KIRKLEES METROPOLITAN COUNCIL

UPDATE OF LIST OF PLANNING APPLICATIONS TO BE DECIDED BY

6 APRIL 2017

Erection of 14 dwellings with integral garages

Client:	Swift Property Management and Consultancy	
Project:	Former Parkam Foods Site Residential Development	
Drawing:	Site Layout	
Date:	Feb 2015	Scale: 1:500@A3
Drawing No:	1434/110	Rev: D

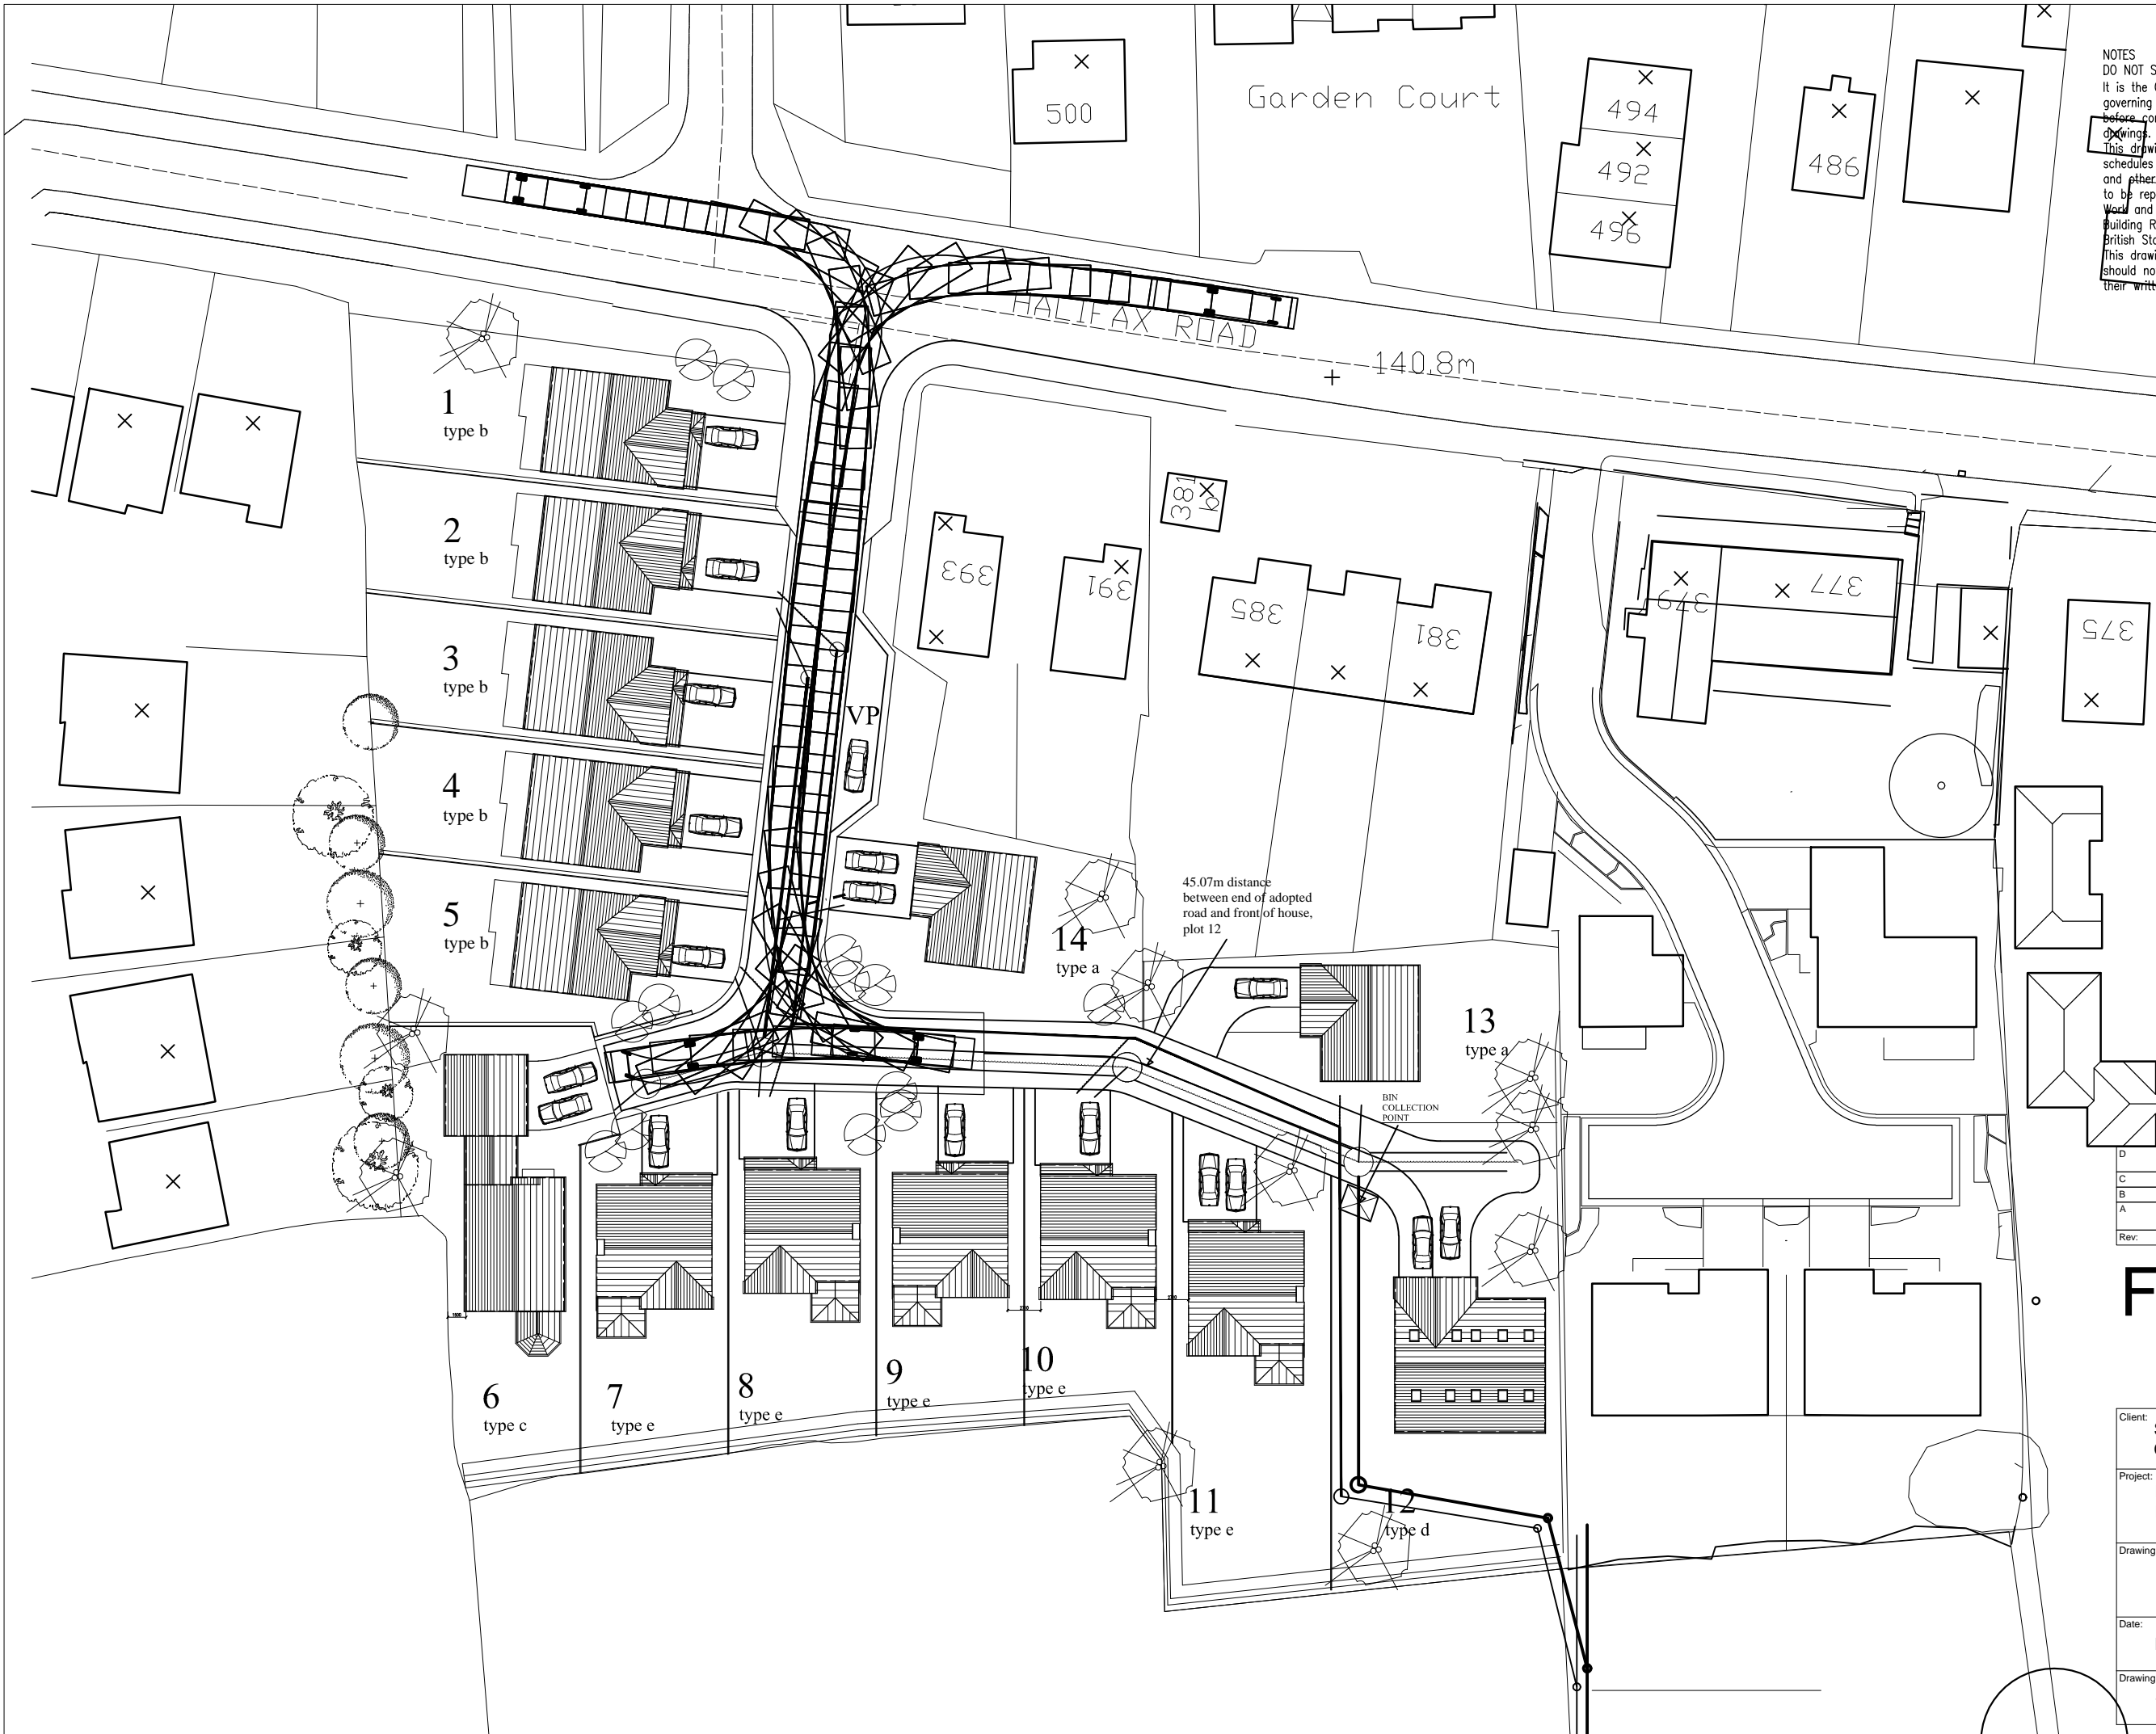
Two minor adjustments were requested to the layout with respect to requirements for emergency vehicle access, and the provision of bin stores. The revised layout plan does not adequately address these matters however they can be addressed by condition and an advisory footnote.

Suggested Condition:

Prior to the development being brought into use details of storage and access for collection of wastes from the premises shall be submitted to and approved in writing by the Local Planning Authority. The approved details shall be provided before first occupation and shall be so retained thereafter.

Suggested Footnote:

Emergency vehicle access and turning is not provided to all dwellings on this development and the applicants are advised to contact their building control provider regarding requirements for the provision of alternative measures to allow emergency fire service access to the proposed dwellings.
